Subject: Response to Goolgowi air quality issues raised by NSW DoPE

The purpose of this letter is to respond to the particulars raised by the NSW Department of Planning and Environment (DoPE) email dated 1 November 2017 in regard to the Air Quality Impact Assessment (AQIA) report prepared by Advitech Environmental entitled *14275 AQIA Goolgowi Poultry Facility Rev0.pdf* (18 September, 2017).

**PROPOSED COMPOSTING
SHED - TYPICAL SHED DETAILS**

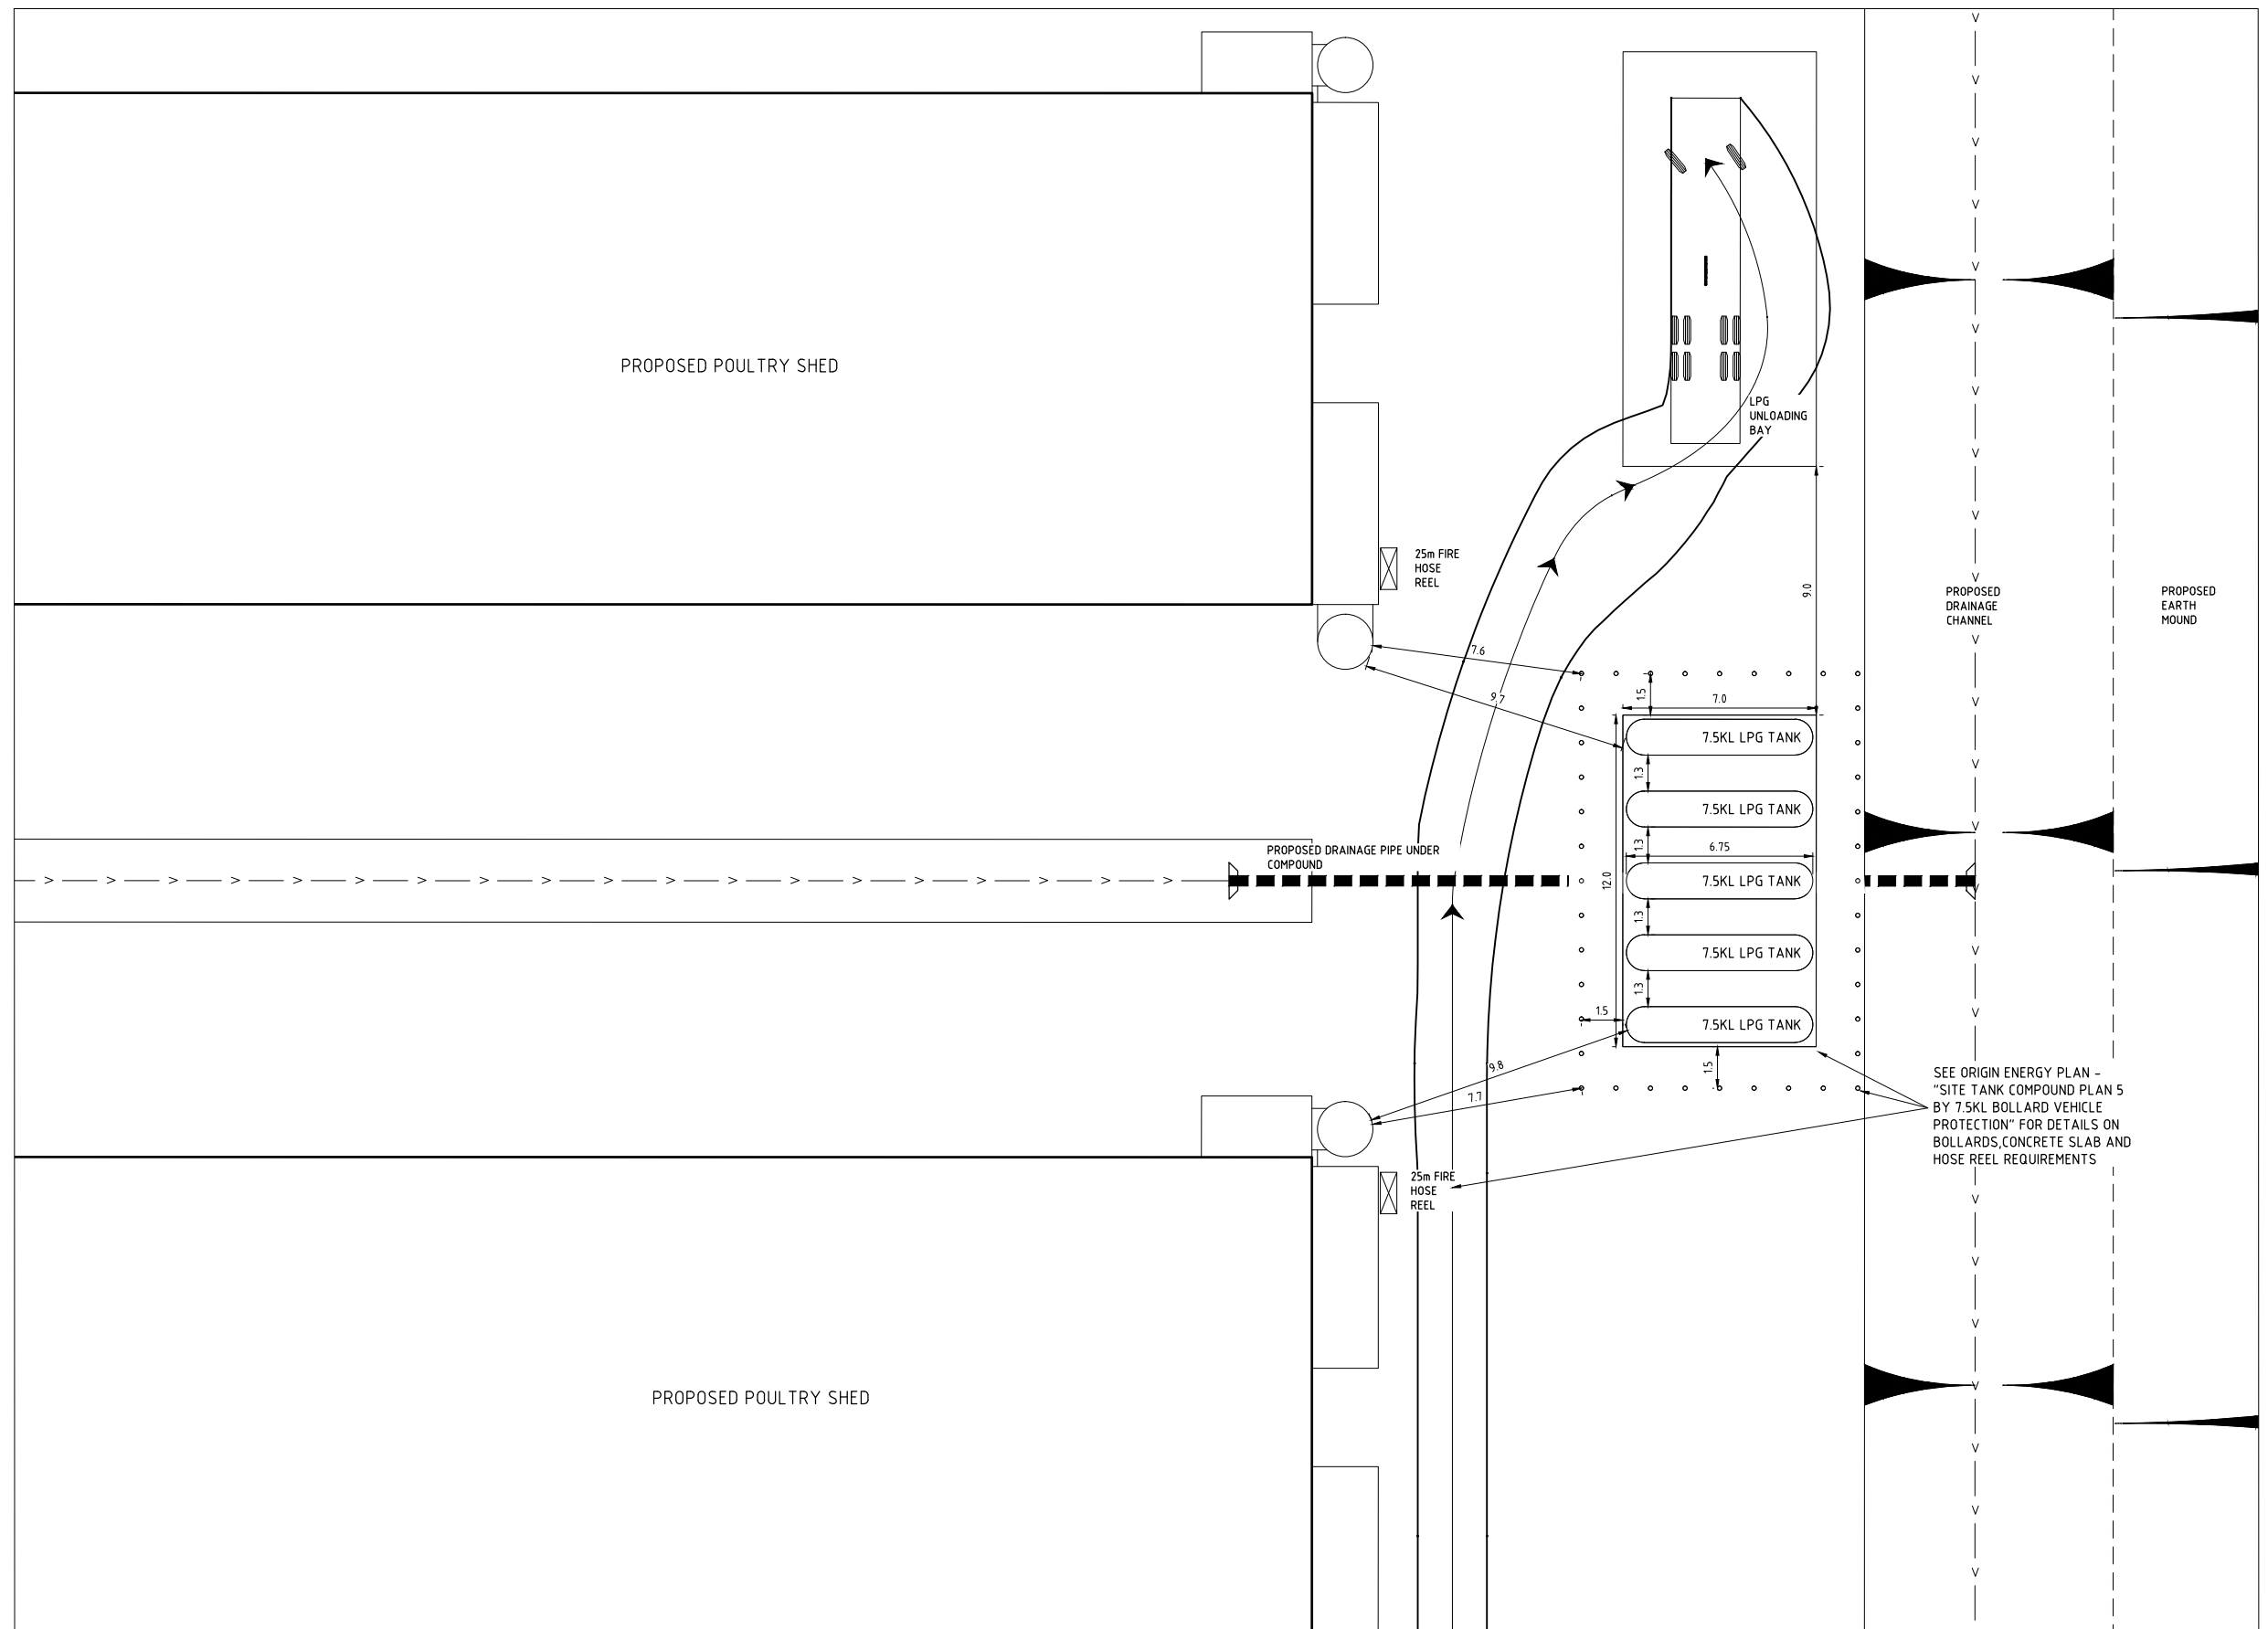
Please provide a justification as to why bird mortalities from normal operations have not been considered in the odour modelling.

Confirm whether on-site composting of daily mortalities as mentioned in the waste assessment has been considered in the odour modelling.

The AQIA report dated 18 September 2017 assumed that bird mortalities from normal operations would be stored in an appropriate intermediary storage bin and taken off-site on a regular basis. Advitech now understands that bird mortalities will be composed on-site in designated composting sheds. Advitech has undertaken additional odour modelling to quantify the potential odour impacts from the composting operations.

The modelling has assumed composting will be undertaken in a designated shed located at each of the individual farms (i.e. one composting shed per 20 poultry sheds) (refer to Figure 3 of Advitech AQIA Report Sep 2017). Each composting shed consists of four separate composting bays (i.e. 400 m² bay) which will be used on a rotation basis (i.e. once a bay is at full capacity, composting will begin at the next bay). The compost is composed of alternating layers of used litter and dead poultry.

A representative odour emission rate was taken from *Heggies. (2006). Woodlawn Alternative Waste Technology Facility - Air Quality Impact Assessment*. The specific odour emission rate for fresh putrescible waste (5.65 OUV/m²/s) is considered appropriate for the composting on site. The composting shed was modelled as a continuous volume source with an assumed active composting area (i.e. actively worked composting bay) of 400 m².
